**Proposed student accommodation and residential flat building
175 – 177 Cleveland Street, Redfern**

I refer to our BCA capability report dated 1 May 2014 and the letter from NSW Planning and Environment dated 9 September 2014 requesting further information.

Geoff Smith
Building Certifier
Vic Lilli and Partners

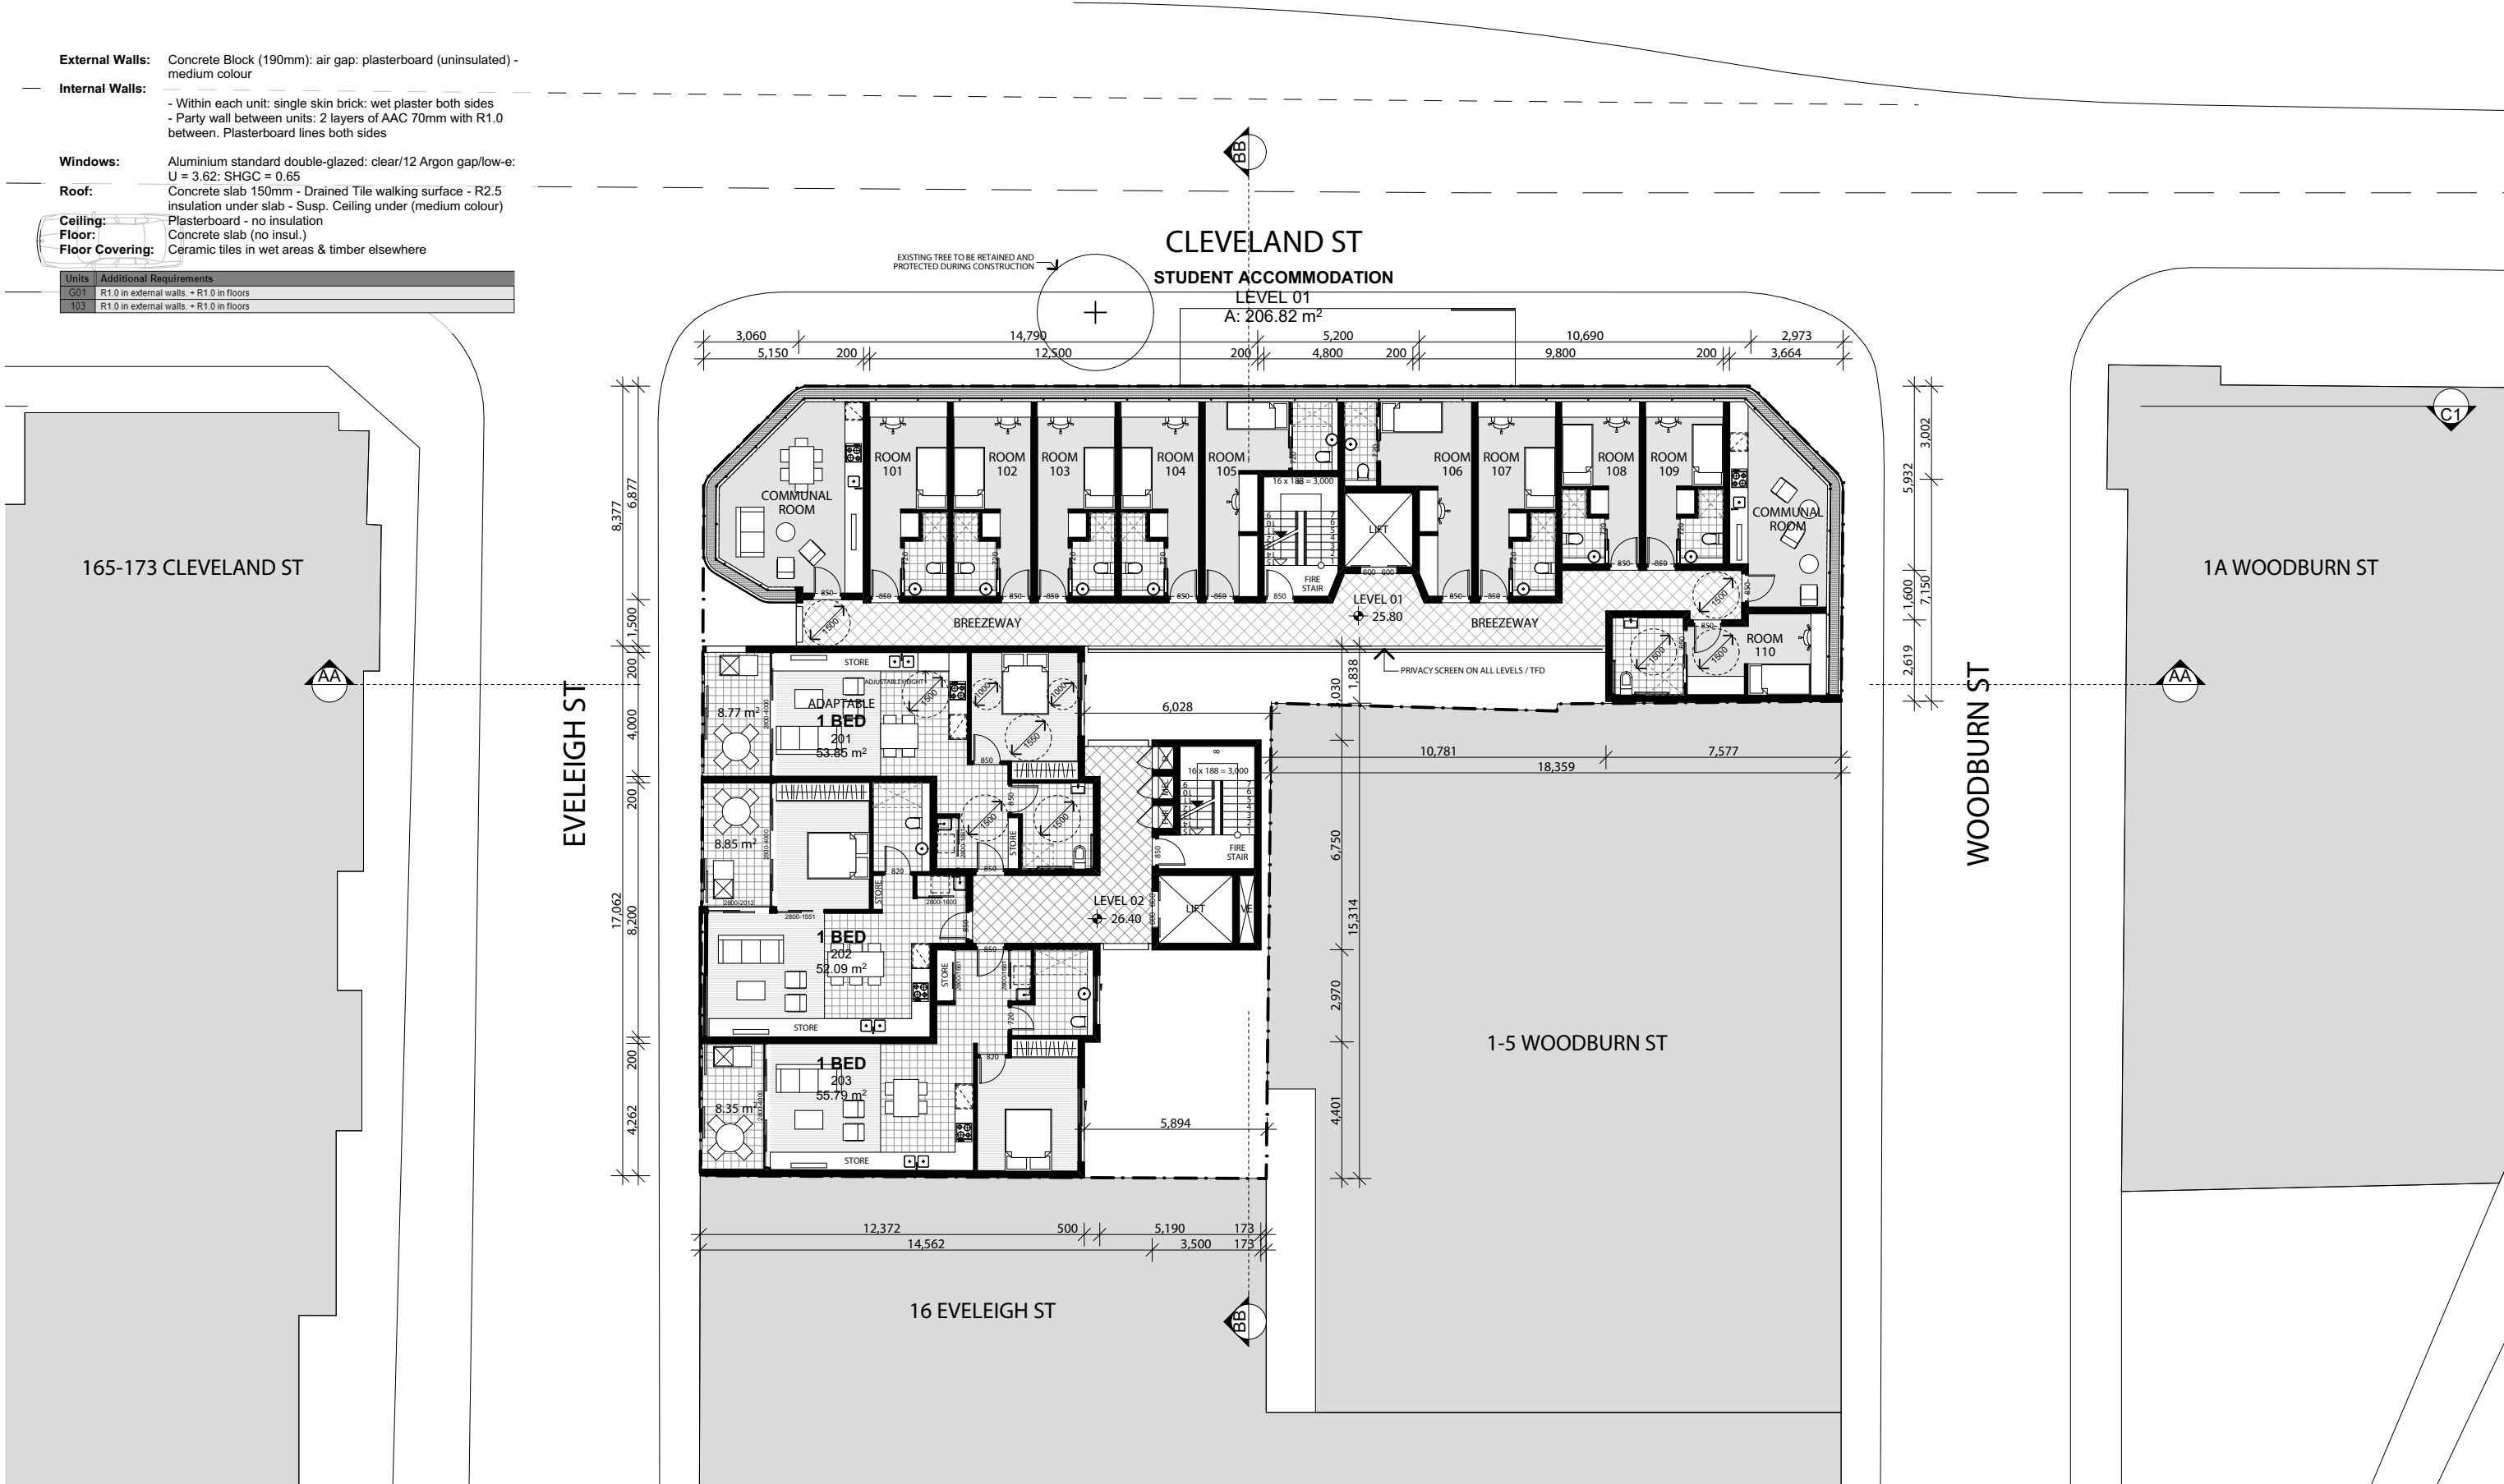
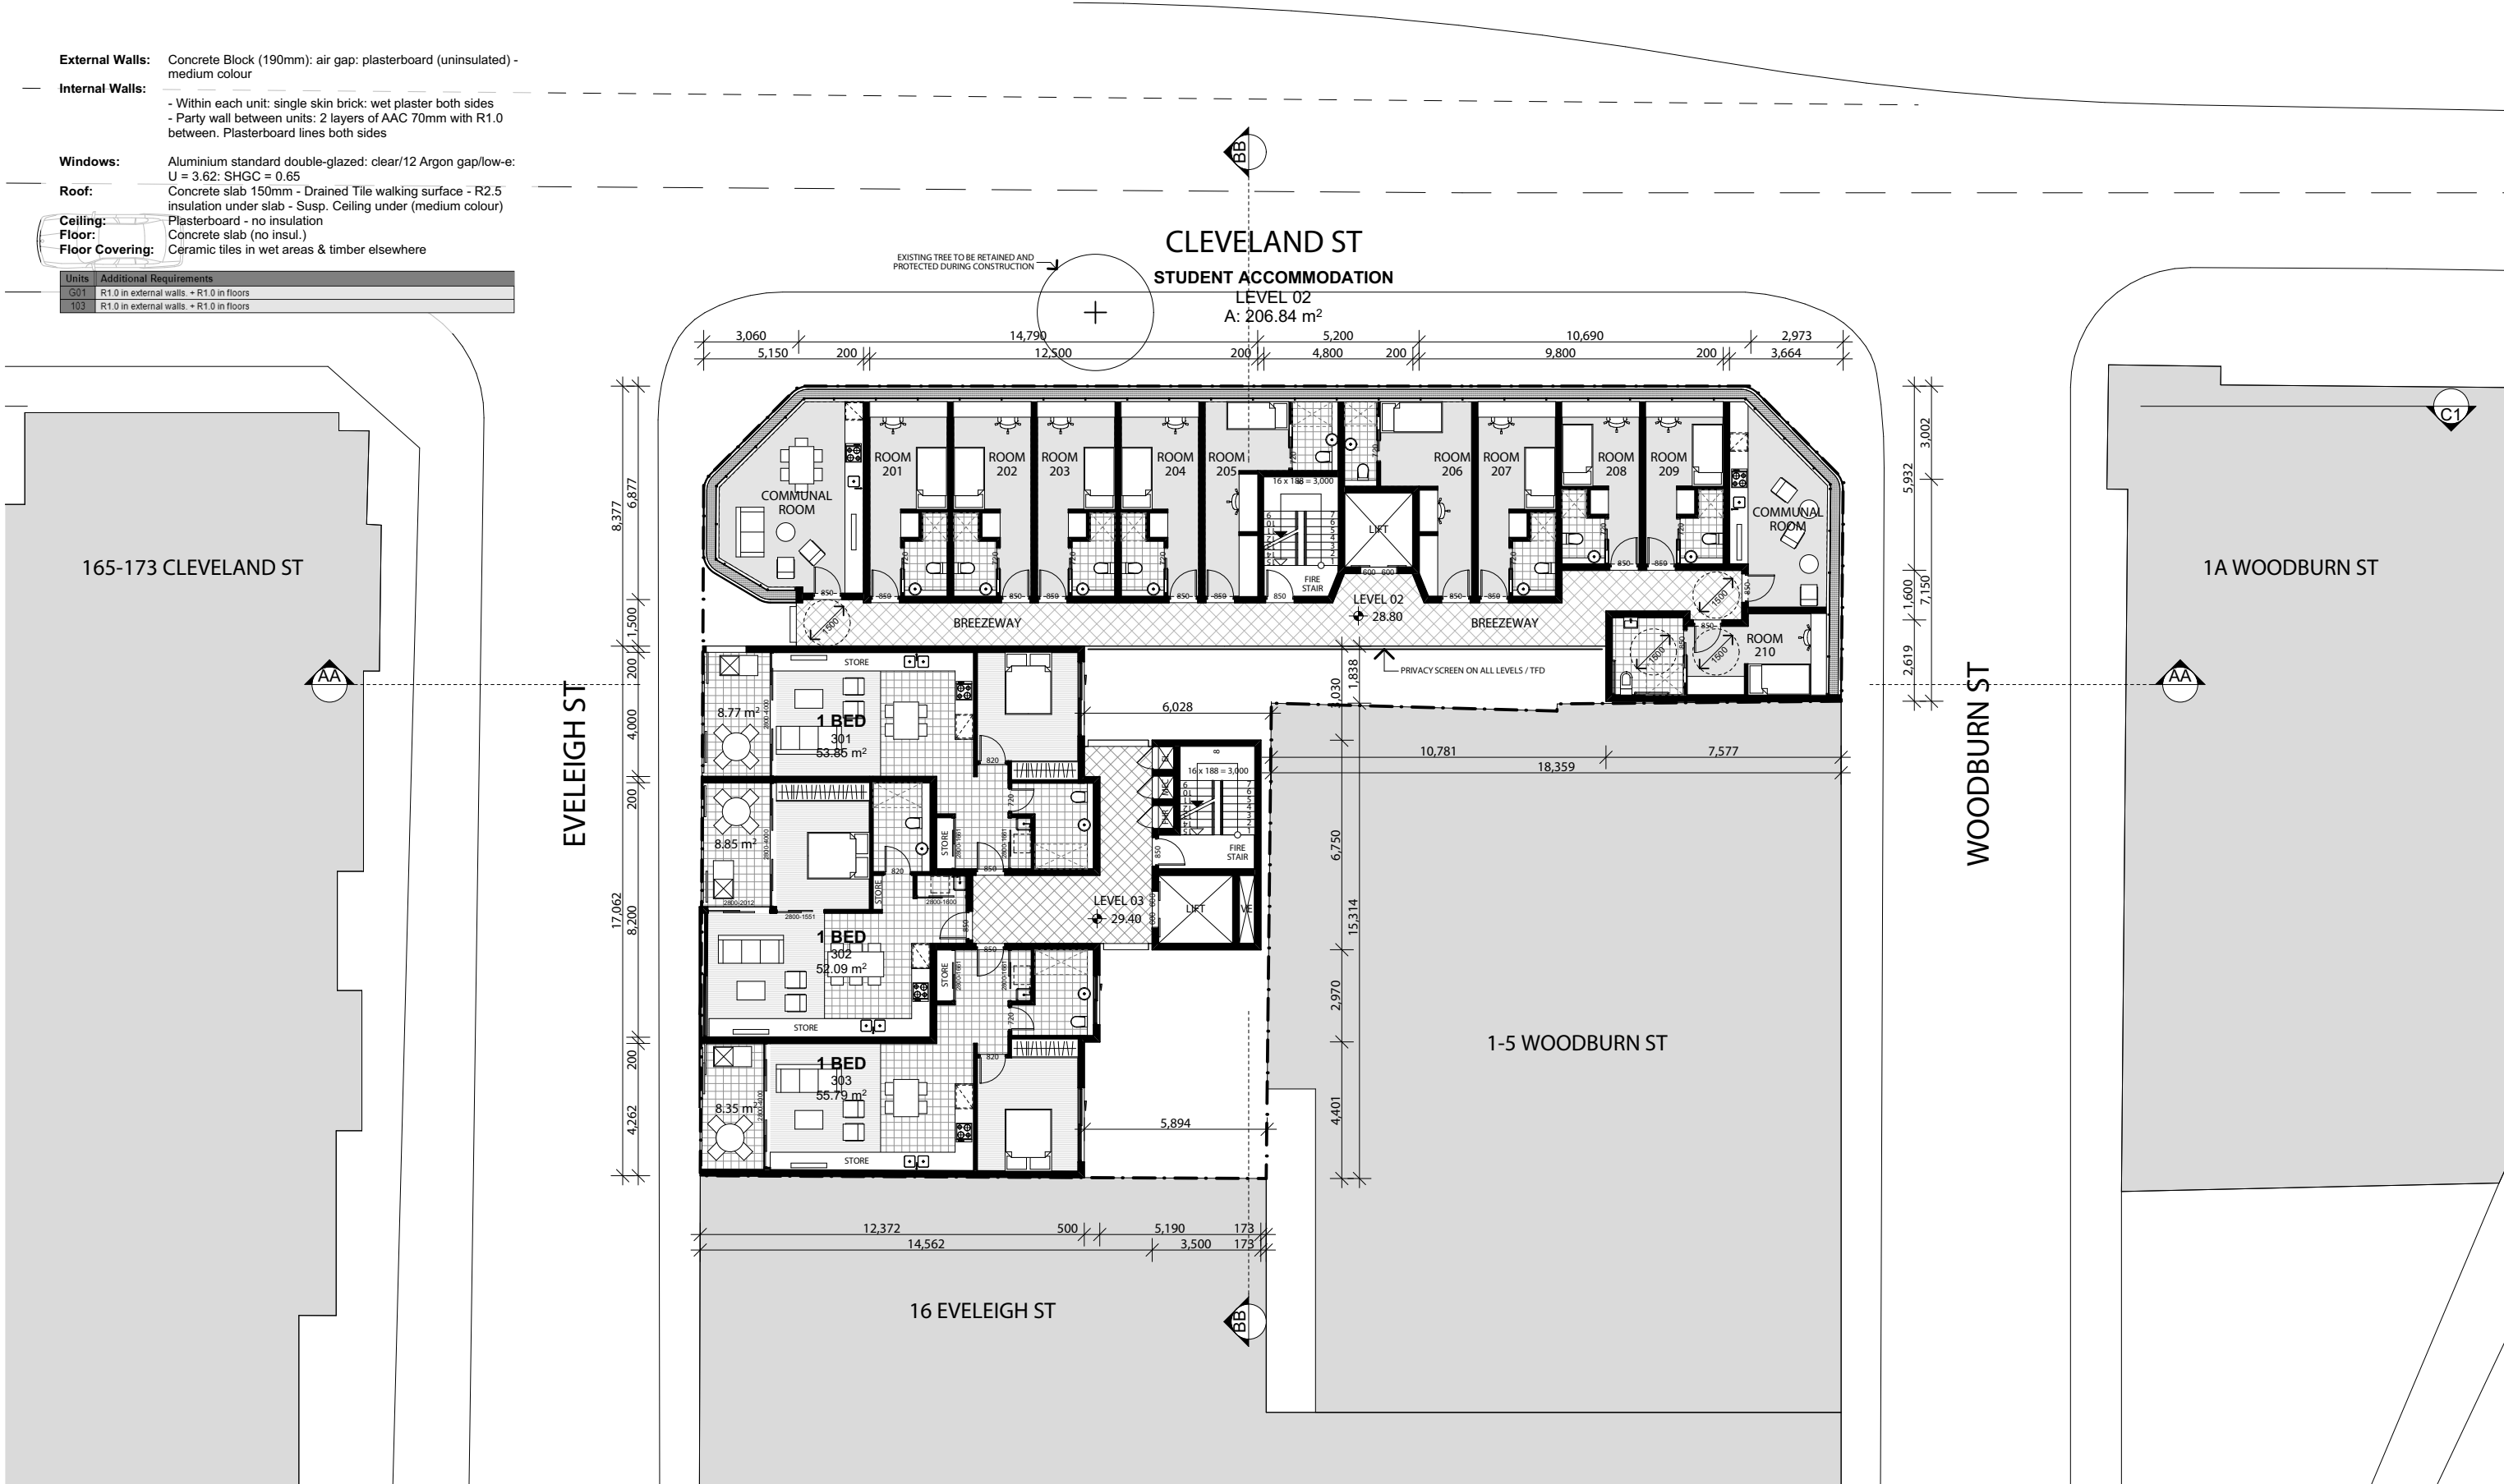
(i) The distance of travel from student sole occupancy units on levels 1-4 to the egress stairway is up to 13.5m which does not comply with the maximum of 6m permitted by BCA Clause D1.4.

I can confirm that compliance with BCA Clause D1.4 is proposed to be addressed via a fire engineered alternative solution which will demonstrate compliance with BCA Performance Requirement DP4. This will occur at the time of issue of construction certificates.
